Our Ref: AB/113/21/DOC

Town & Country Planning Act 1990 (as amended)
Town and Country Planning (Development Management Procedure) (England) Order 2015
Approval of details reserved by condition imposed under AB/39/18/PL relating to conditions 3-
Construction Management Plan, 4-surface water drainage & 5-foul & surface water sewerage disposal.
30 Ellis Close Arundel BN18 9LG

Arun District Council have decided to **REFUSE details reserved by condition for the following reasons:**

Drawing Title **Topographical Survey, Proposed Levels & Drainage GA**

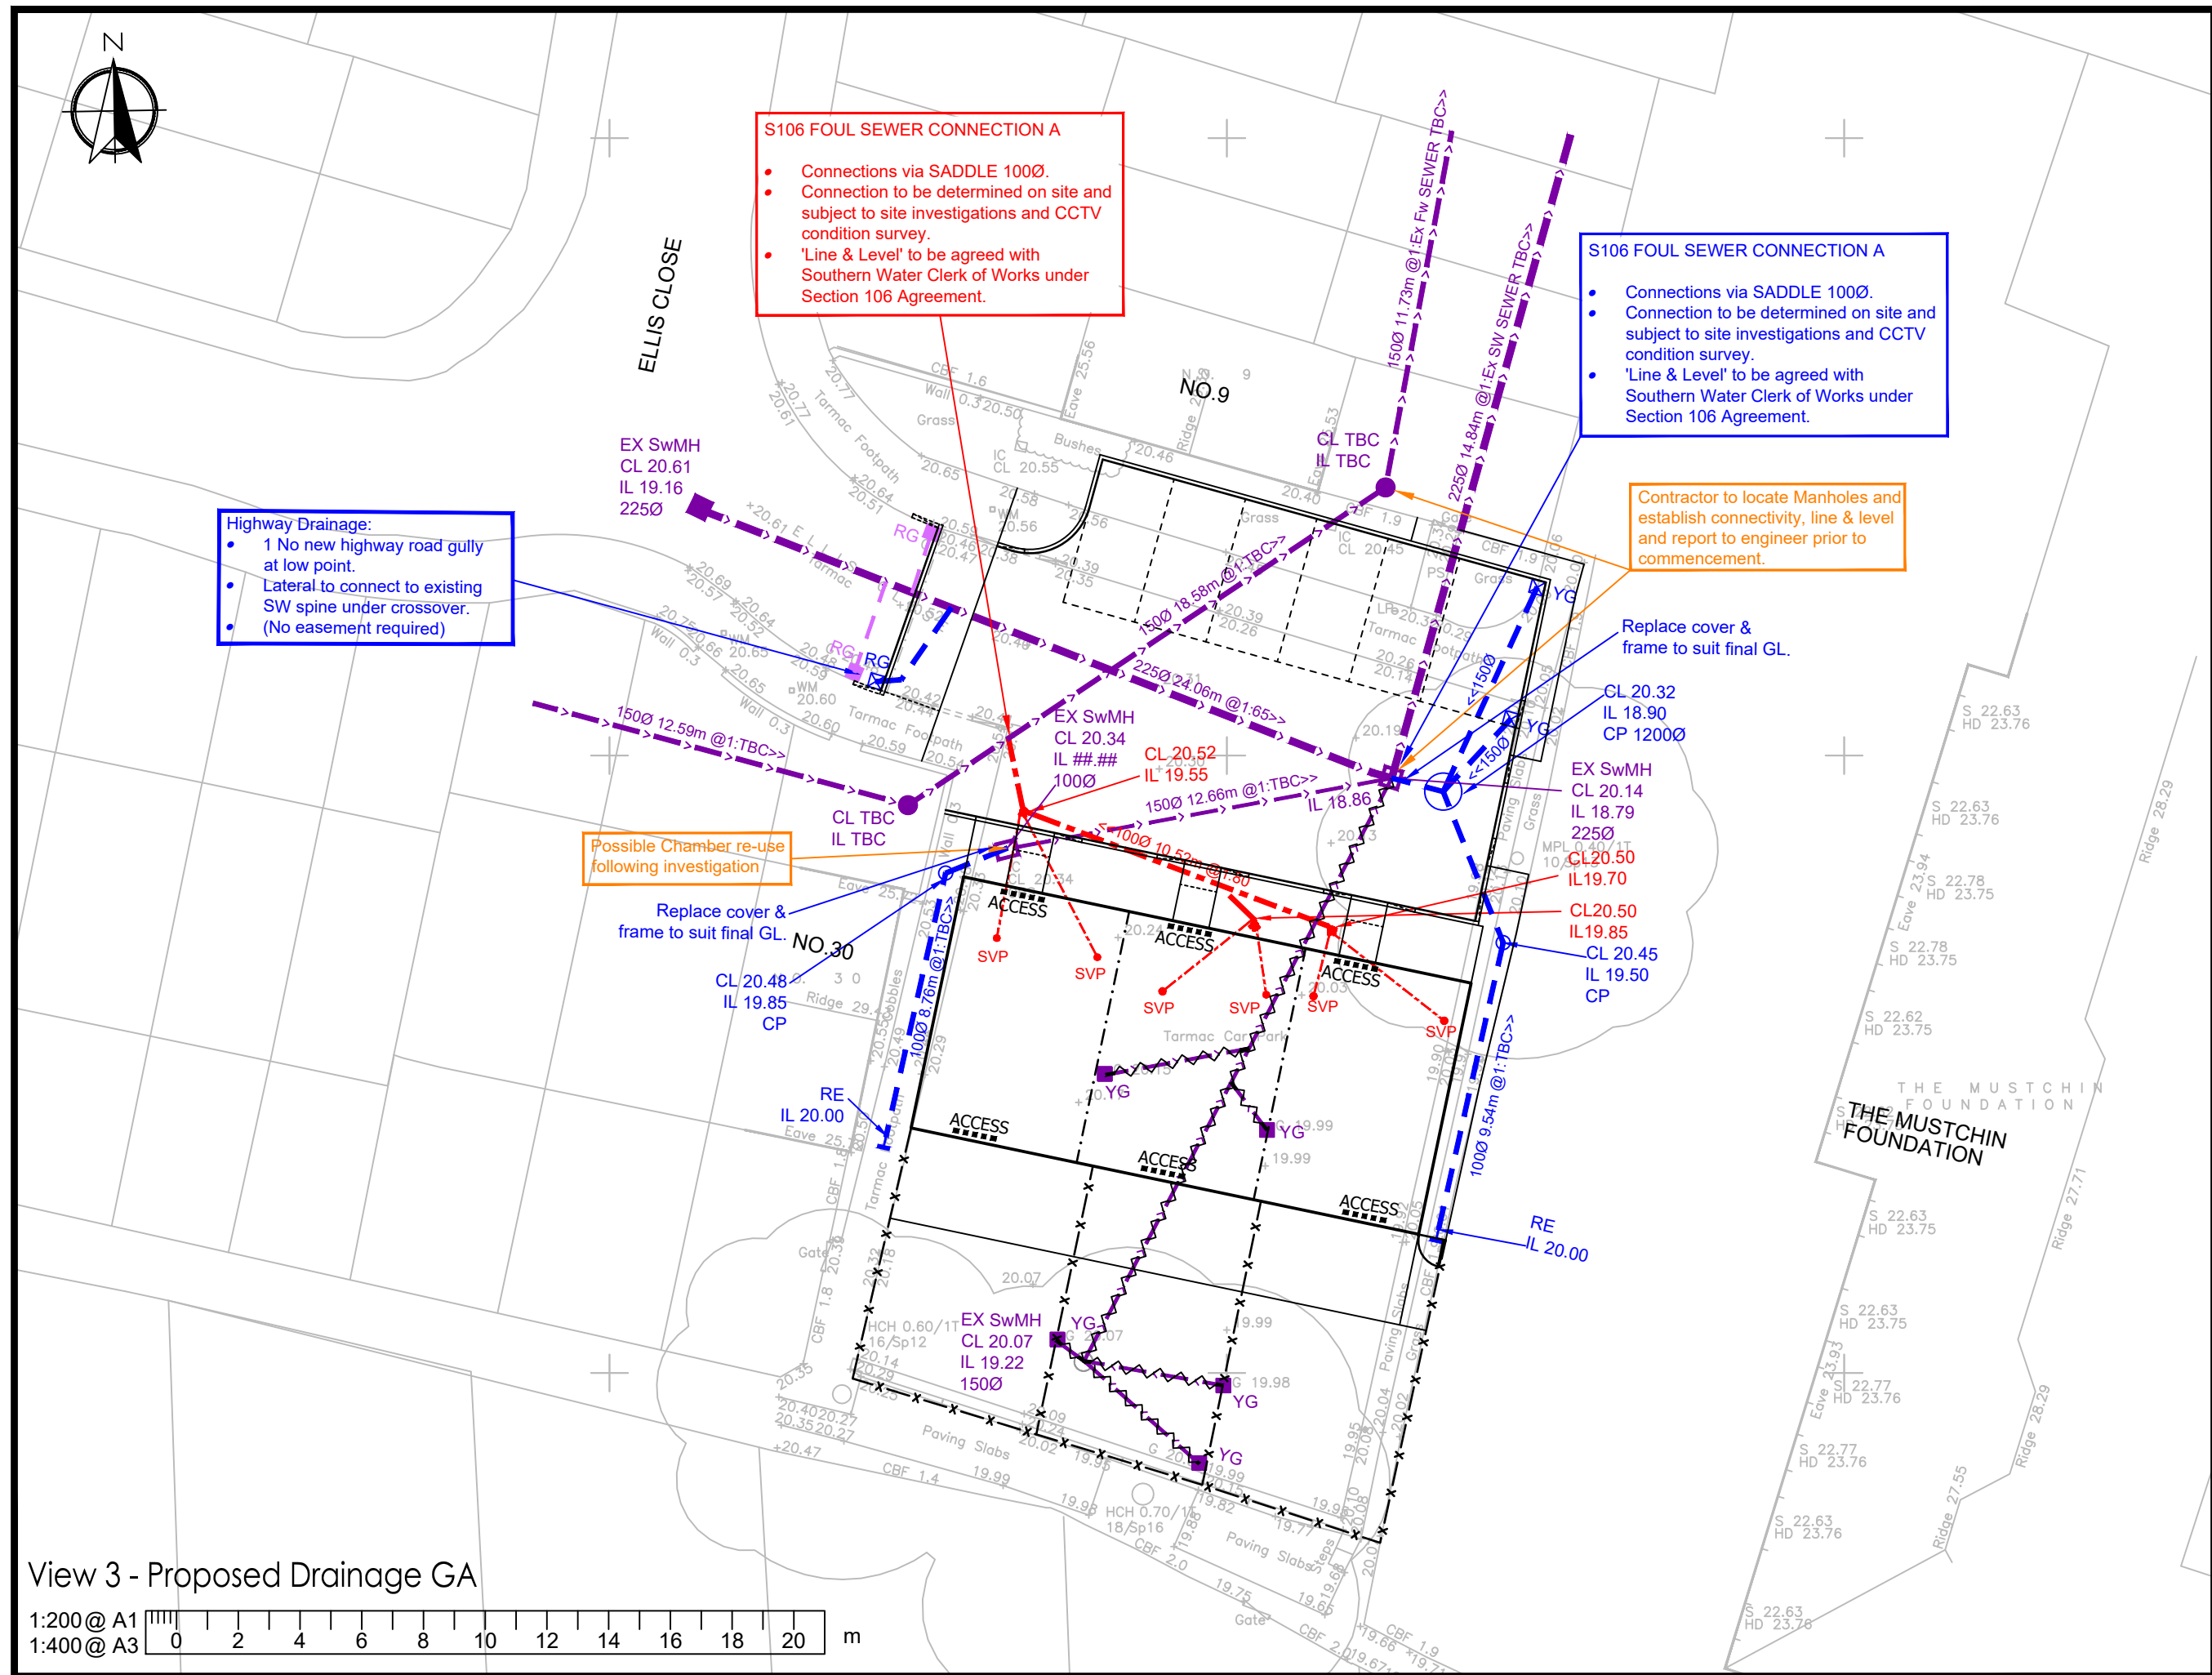
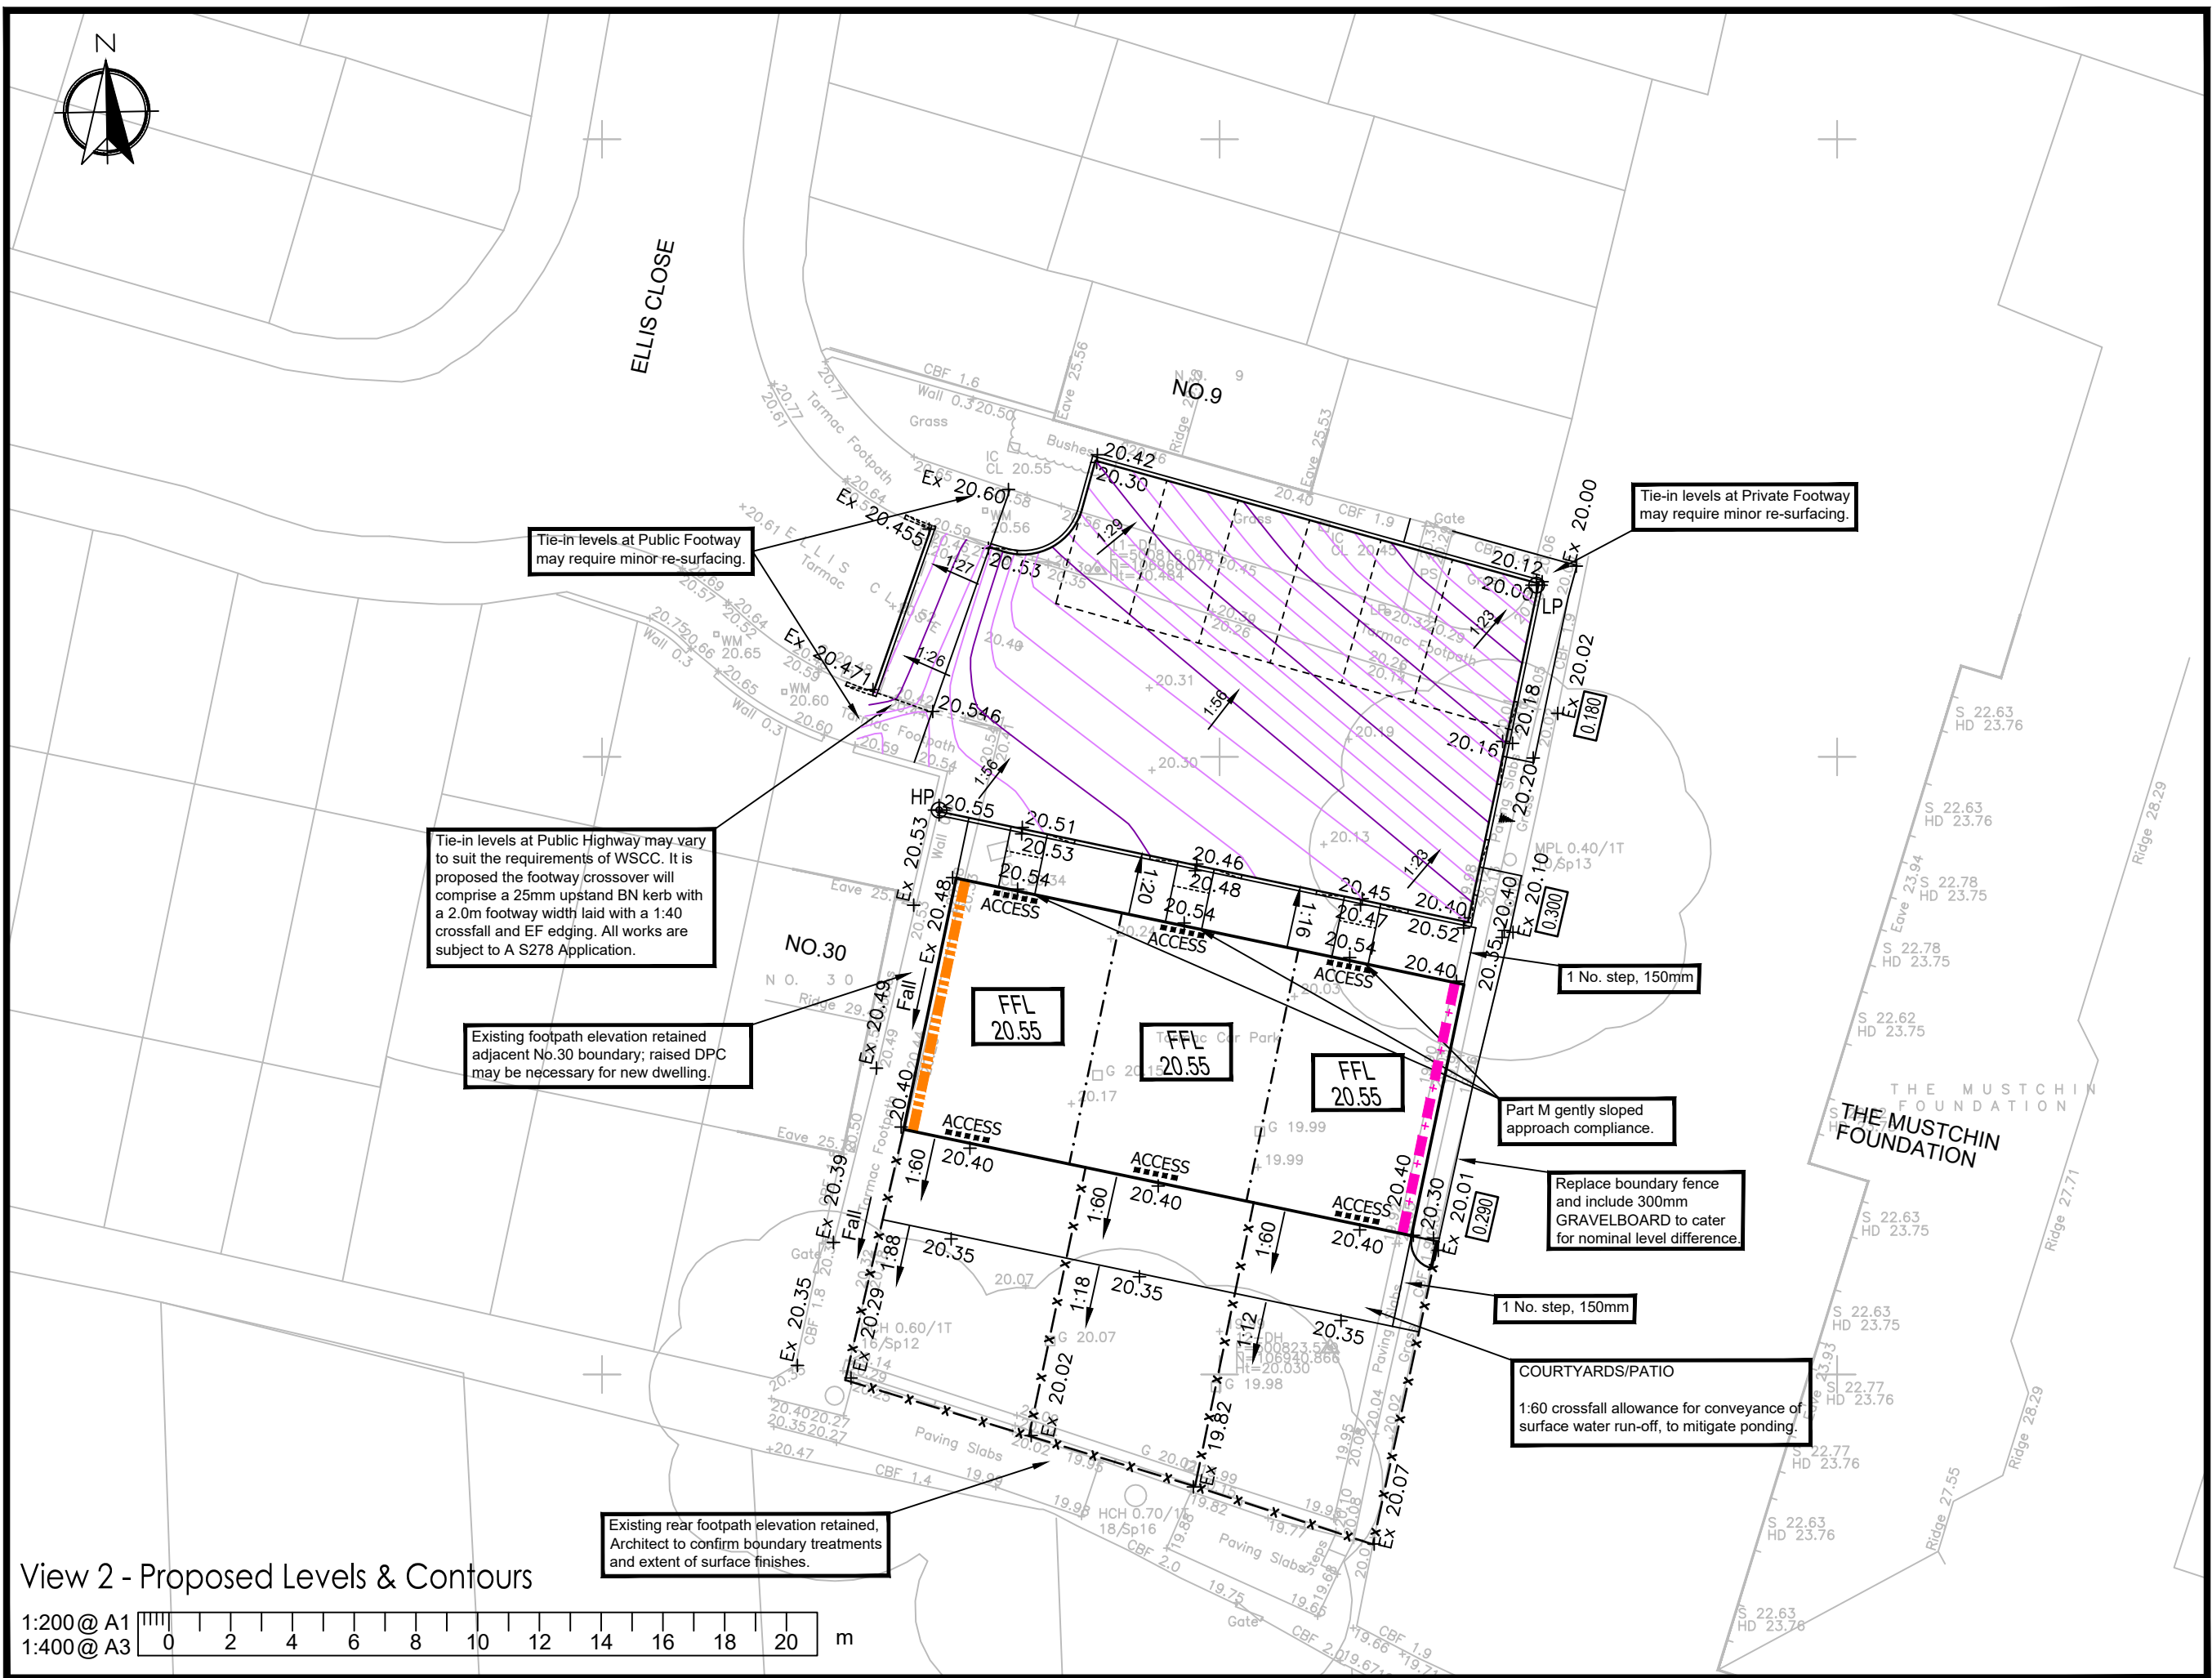
1. On the assumption that the surface water sewer being connected to is deemed vested under 2011 legislation, please provide evidence of Southern Water's approvals to the connections is required.

2. New highway gully to be connected via oblique junction - add note.
3. Connections to be made to existing manholes (2no.) to be made at soffit to soffit level - indicate level and connecting pipe diameter.

4. Upgrade yard gullies to road gullies to provide increased resilience.
5. Where existing surface water drain is to be grubbed up - add note that manhole is to be made good inside.

6. Proposed manhole cover replacements (2no.) to be ductile iron. Please also specify loading grade.
7. Show rainwater pipes including points of connection. Connections to be made to manholes where possible or via oblique junctions.

8. Note referring to the proposed connection to the existing manhole in the car park area refers to a saddle connection and foul and needs adjusting.
9. 1200mm catchpit construction detail - specify ductile iron cover/frame & polypropylene coated step rungs/irons.
